REQUEST

Current Zoning: R-3 (single family residential)
Proposed Zoning: R-12MF(CD) (multifamily residential, conditional)

Approximately 9.96 acres located on the east side of Steele Creek Road and south of Erwin Road.

The petition proposes to rezone a property currently occupied by one single family home to R-12MF(CD) to allow the development of a 119 unit senior independent living community at a density of 11.95 dwelling units per acre.

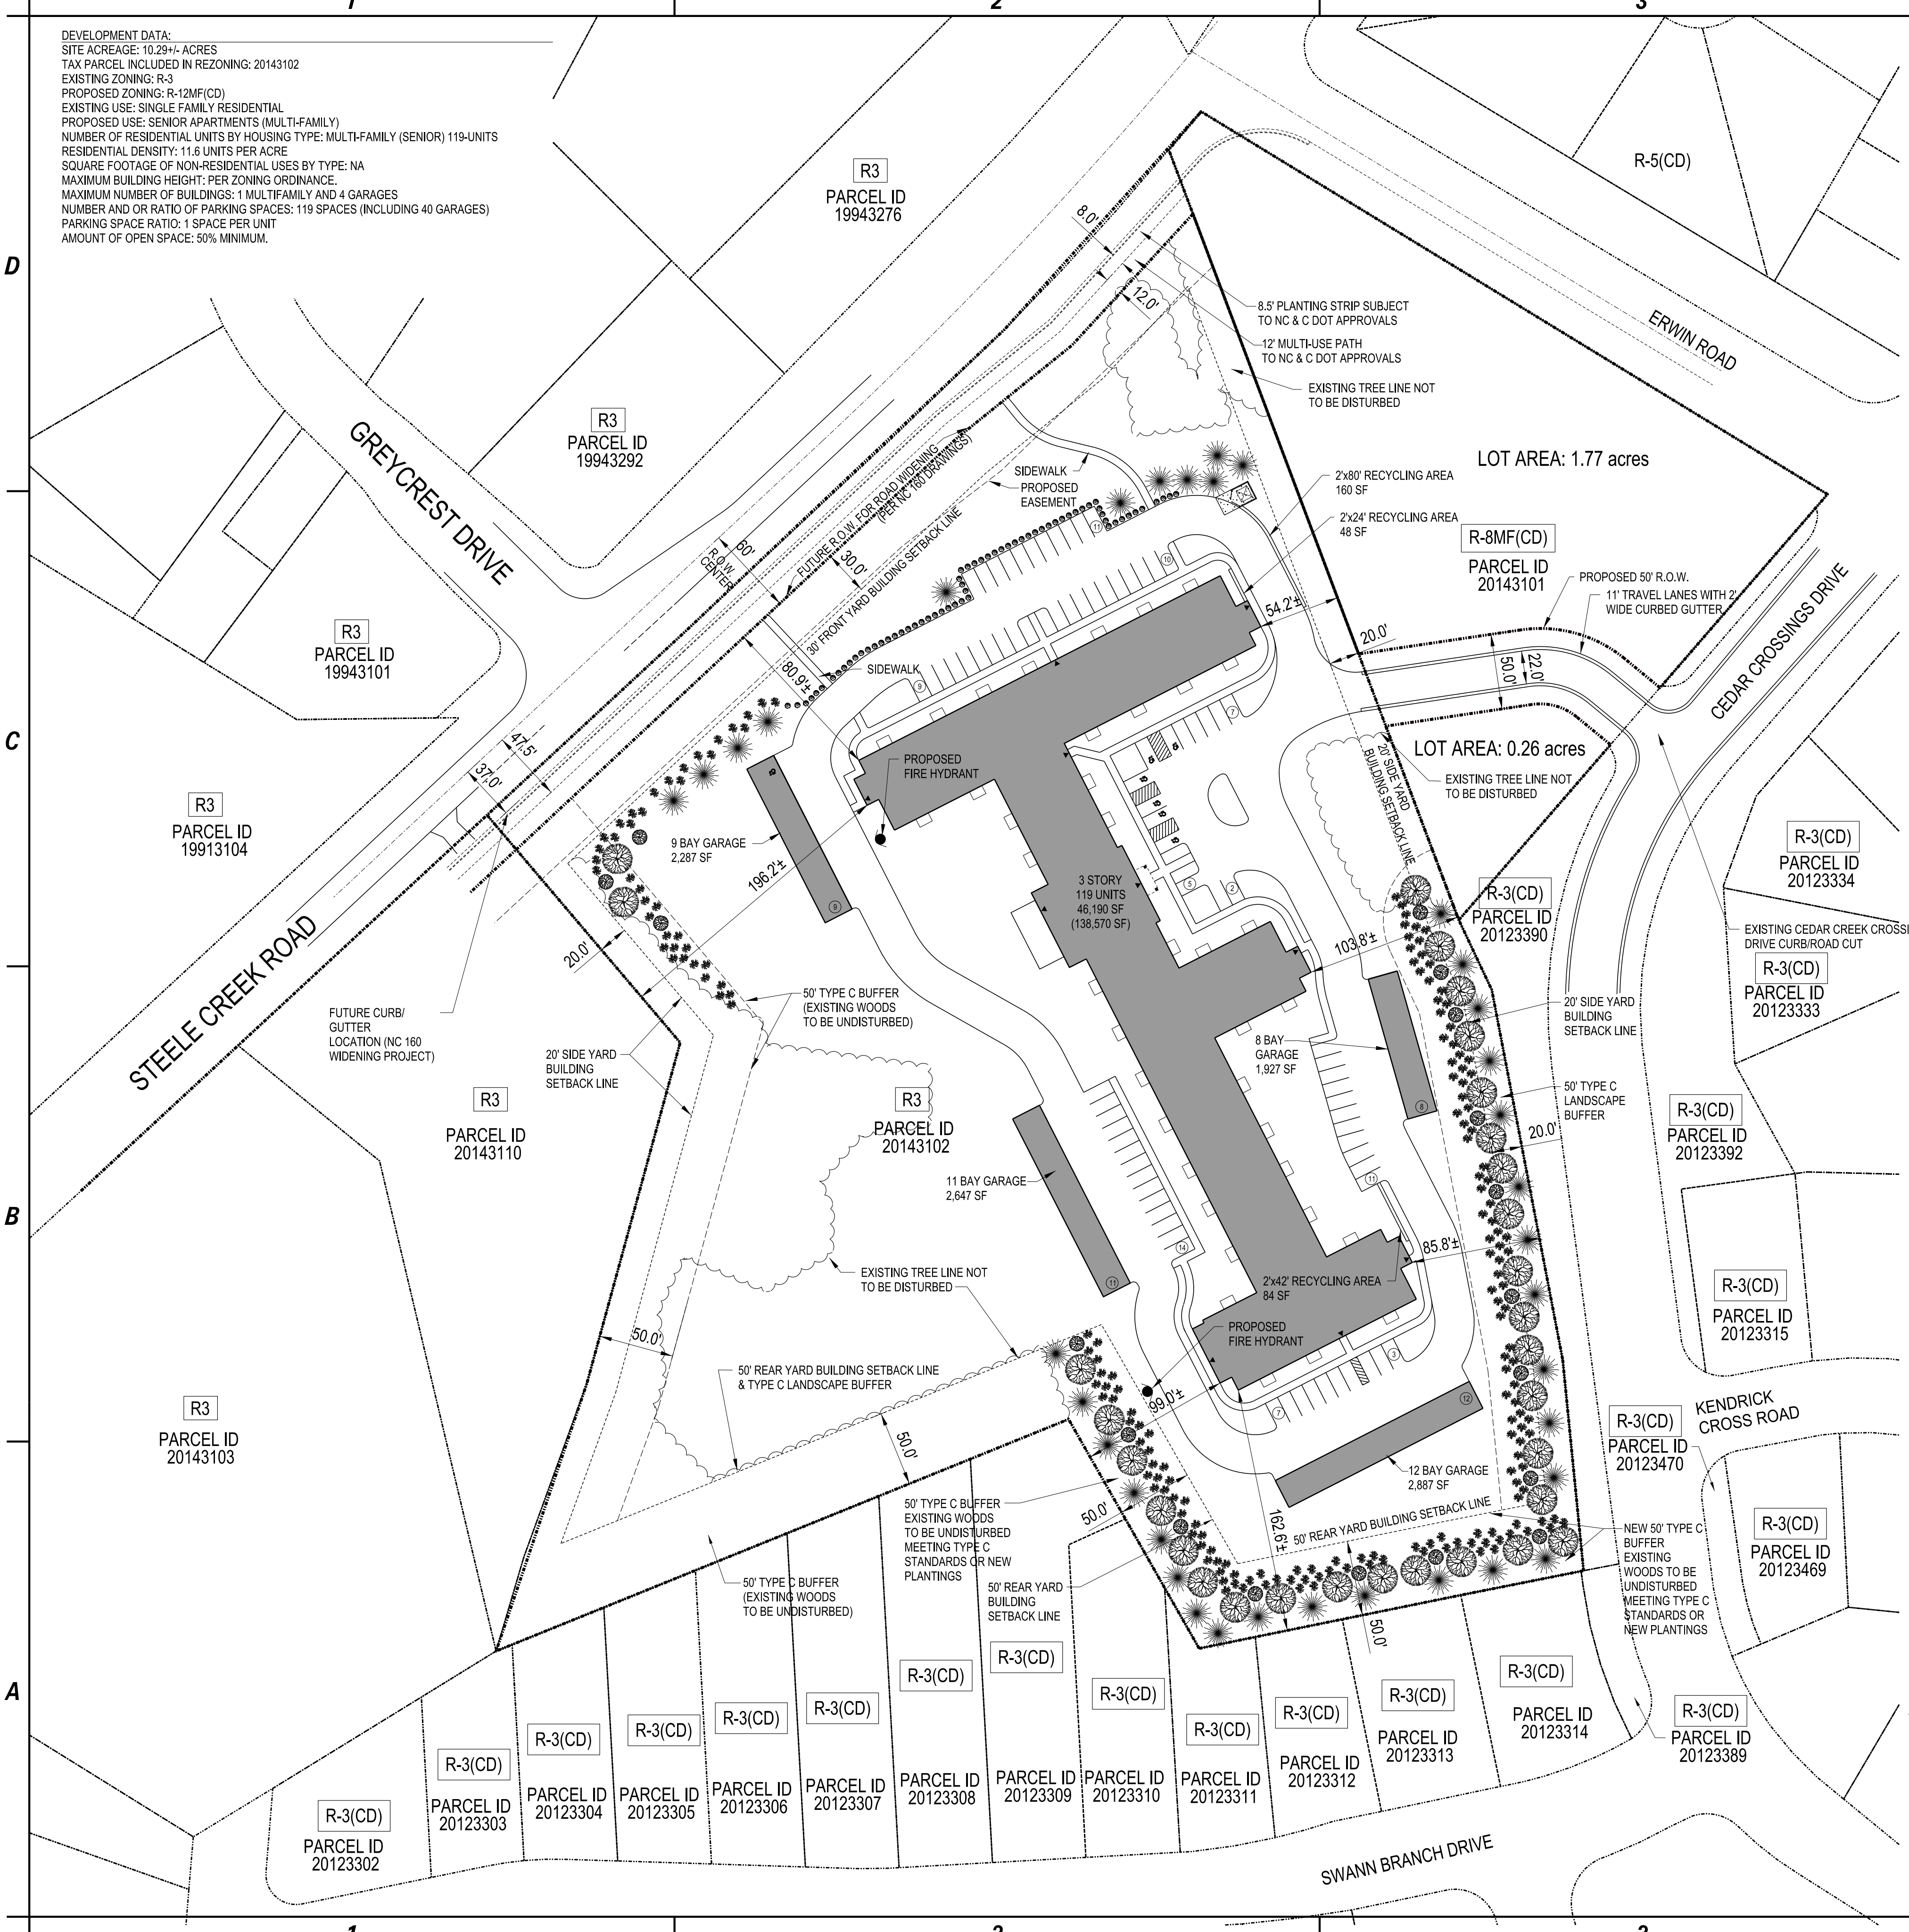
1. The petitioner should revise the site plan and conditional note (Section Transportation.7.) to commit to a north-eastbound 100' right-turn lane into the from NC 160 into Erwin Drive. Please clearly label and dimension the right turn lane.
Updated Comment from 09-14-2020 Site Plan: It appears this right turn lane is there, however, it is not labeled nor dimensioned.

2. The petitioner should revise the site plan and conditional note (Section Transportation.7.) to commit to construct a south-westbound left-turn lane with 150' of storage and appropriate left-turn lane tapers based on the speed limit from NC 160 into Erwin Drive.
Updated Comment with 09-14-2020 Site Plan: This left turn lane has been requested during every previous review phase and in multiple resubmittal meetings. Both NCDOT and CDOT cannot require this left turn lane and, as a result, the petitioner has opted to not include this left turn lane in their site plan and scope of work. This note is not meant to deter approval of this petition, rather, this note serves to provide transparency of information from previous reviews and discussions between all parties.

3. Include language in the notes that validation of this easement will be provided to CDOT before final permitting.

4. Site is still not showing enough protected tree save. Tree save is required to be 15% of total area made up of existing trees. Replanted tree save is not an option for this site.
